PLANNING APPLICATION REPORT**REF NO:** **WA/36/10/****LOCATION:** Ashurst
 Binsted Lane
 Binsted**PROPOSAL:** Retention of boundary fence and proposed replacement of the main gate.**SITE AND SURROUNDINGS**

ASHURST
BINSTED LANE
BINSTED BN18 0LPtitle PLANNING APP FOR WALLS /
FENCE ON BINSTED LANE

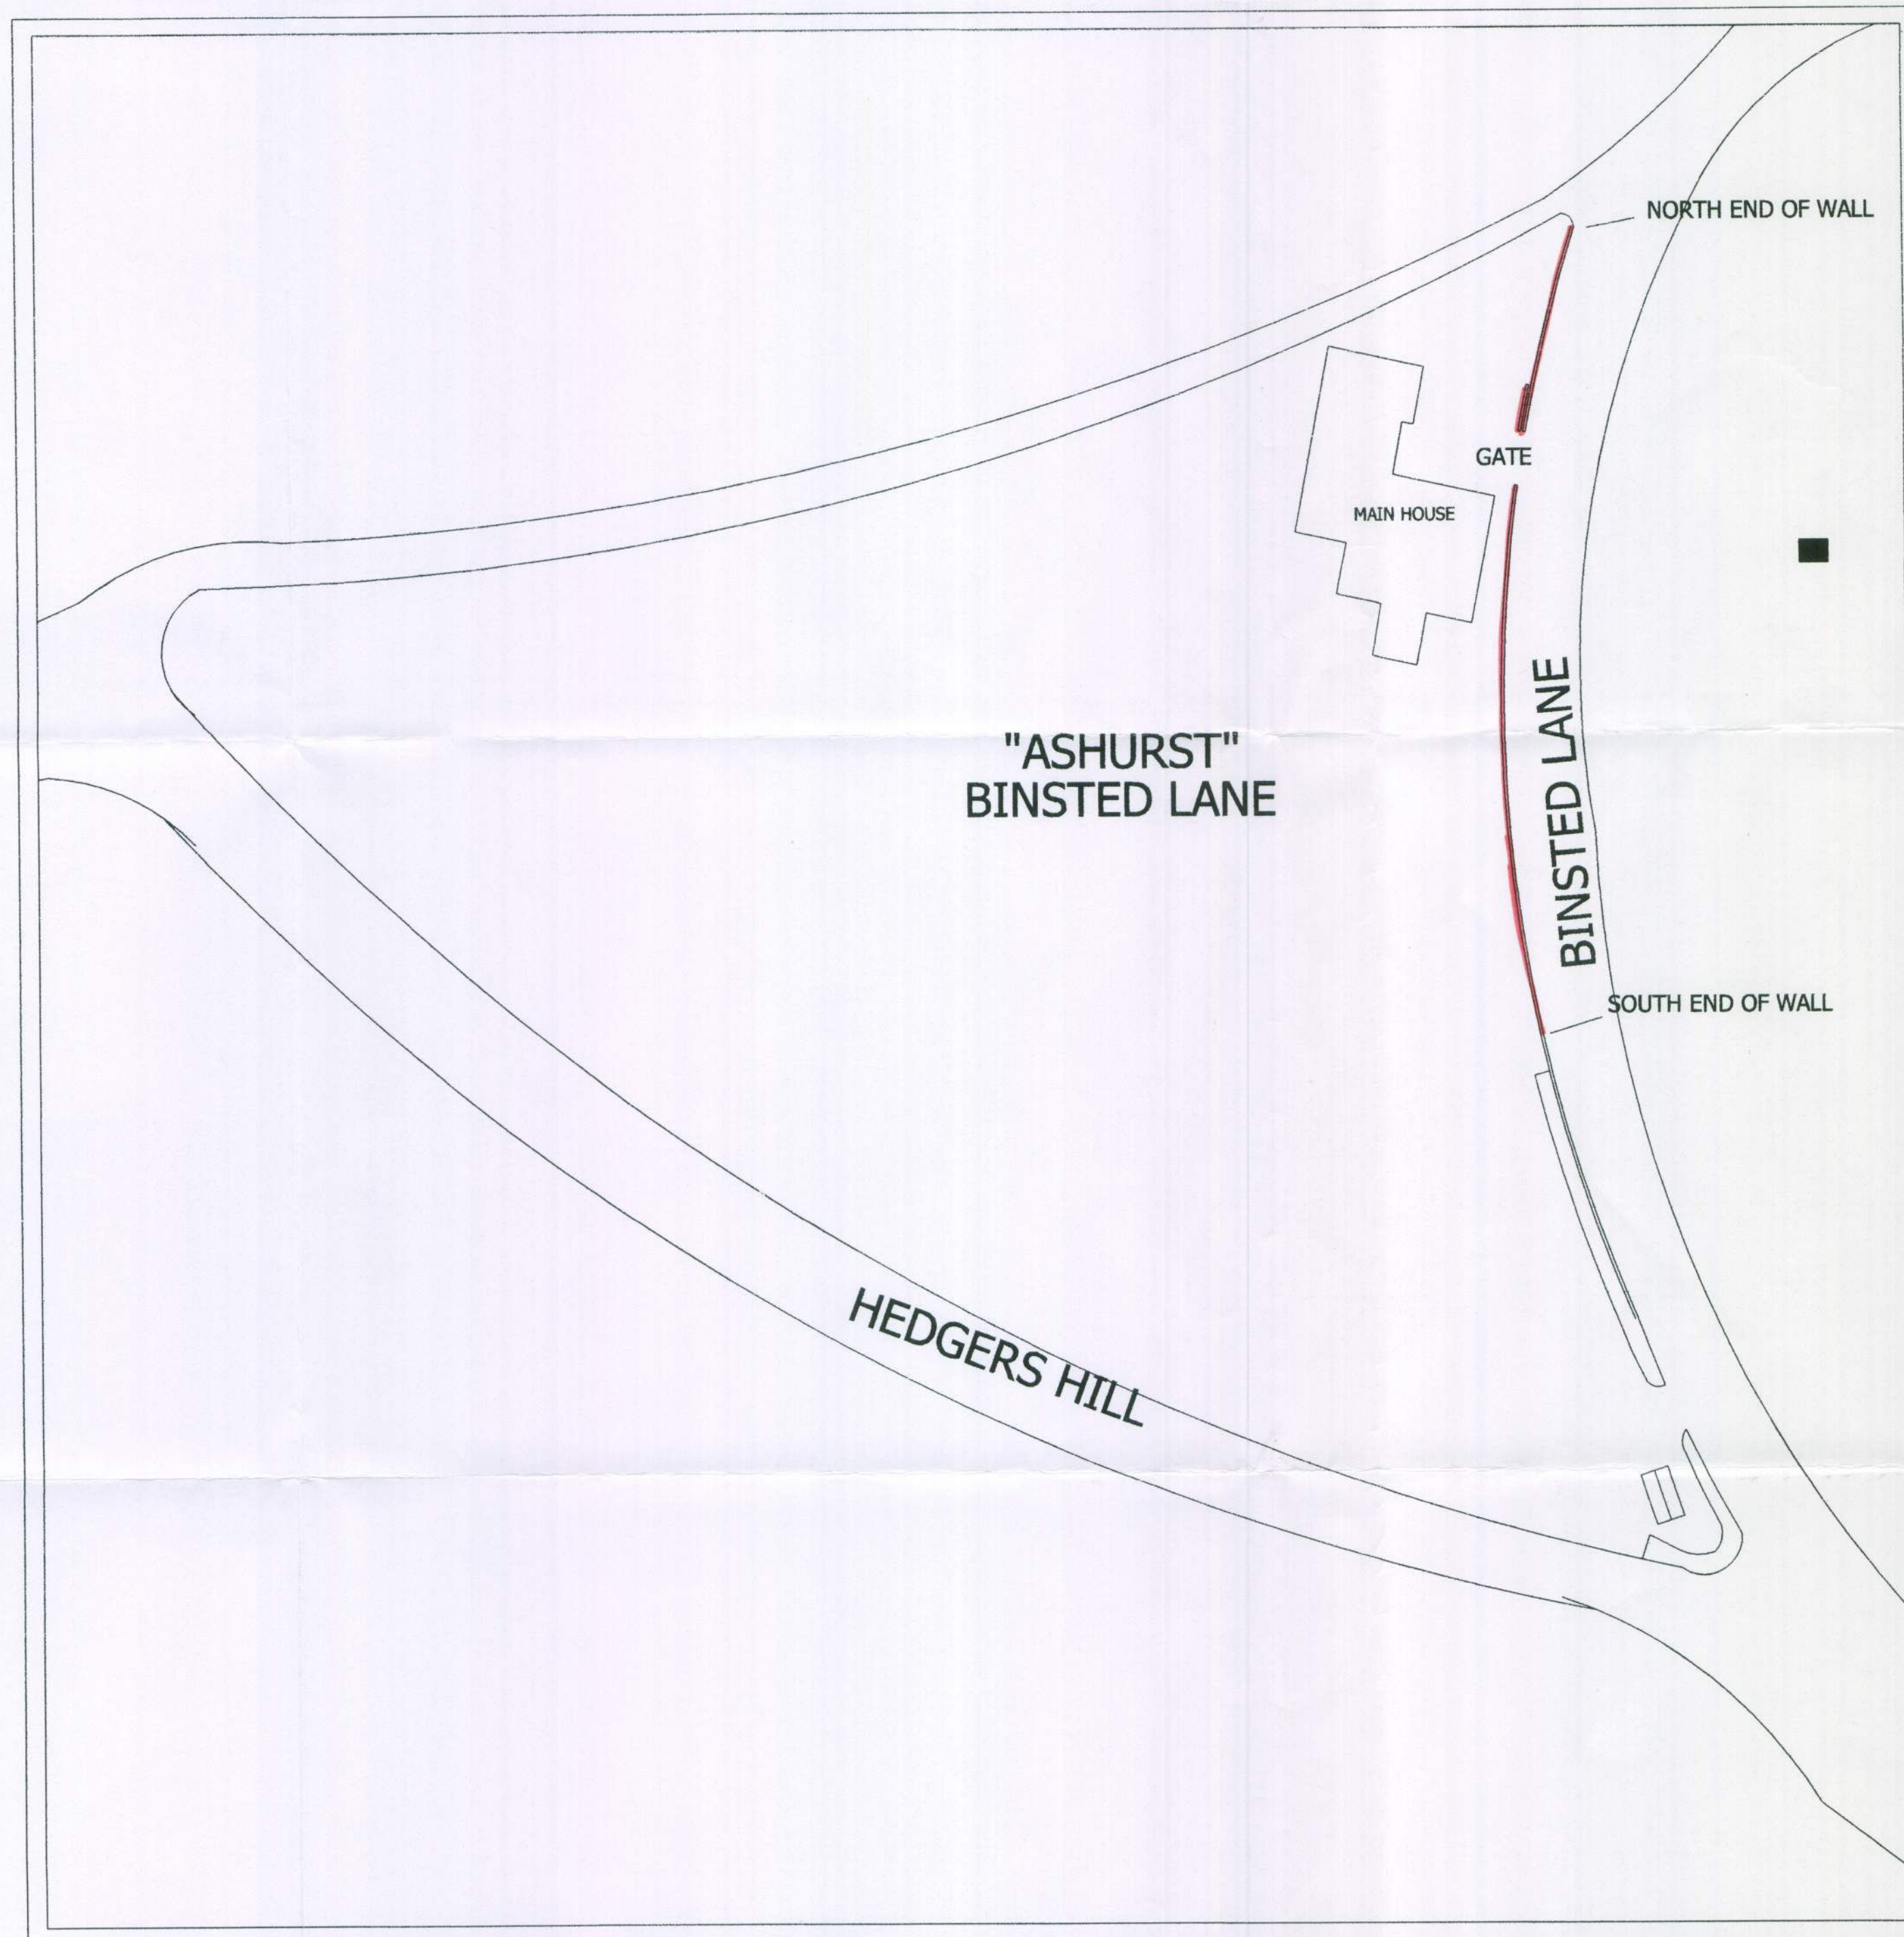
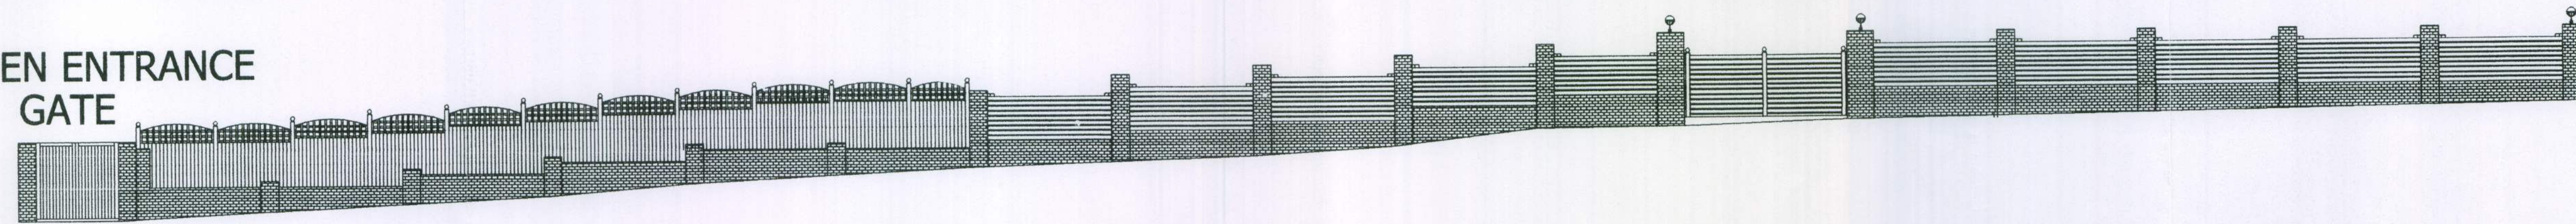
District Engineers - Structural calculations are required to justify stability and strength of piers for lateral wind forces.

District Parks and Greenspace - Due to the proximity of the fence line to the road there is not sufficient space to facilitate any significant planting which could soften the visual impact.

Comments noted. The original application allowed for sight lines. The reinstatement of some form of hedge screening is essential to break up the urban form of this structure.

The proposal is considered to conflict with relevant Development Plan policies in that the design, height and extent of the existing fence is out-of-keeping with the rural street scene which is predominantly hedging or flint walling. The existing fencing has been constructed without Planning Approval as it is not in accordance with the Approval WA/3/03 and appears very urban in this countryside location as it is out-of-character.

This application follows an appeal on an enforcement to remove the walling which was built without Planning Approval (CON/WA/11/05). The Inspector commented that "the constructed wall is tall, with particular large piers adjacent to the gate and extends for a significant distance along the highway boundary. The design because of its height, length, piers, panels and iron gates is not sympathetic to a rural area but has a substantial and unacceptable urbanising impact". He went on to explain that whilst a fence panel would mellow over time the overall design and length would not overcome the harm. It is considered that the sections of walling have now been replaced with fencing does not enhance the situation or soften it in any way. Therefore this does not overcome the Inspector's objections.

The existing wall, fencing and trellis, along with the brick pillars with decorative pinnacle on top are totally out-of-character with the rural countryside and as the Inspector concluded it has an unacceptable urbanising effect. The applicant has been advised on several occasions that traditional flint walling would be acceptable, but brick wall and fencing is not. Alternatively, hedgerow could be re-instated. Therefore, the proposal is a visual intrusion and unacceptable.

The original wall and gates approved WA/3/03 allowed for visibility splays of 2m x 45m in each direction as required by the Highway Authority. County Highways have commented that the gates should be sited 5m back from the edge of the carriageway of Binsted Lane.

- 1 The boundary wall, fencing and trellis, by reason of its siting, length, height and design, would represent an unacceptable form of urbanisation and would adversely affect the visual amenities of the rural locality in that it would be obtrusive in the landscape and prominent from surrounding viewpoints. The proposal would therefore be contrary to policies GEN3, GEN7 of the Arun District Local Plan.
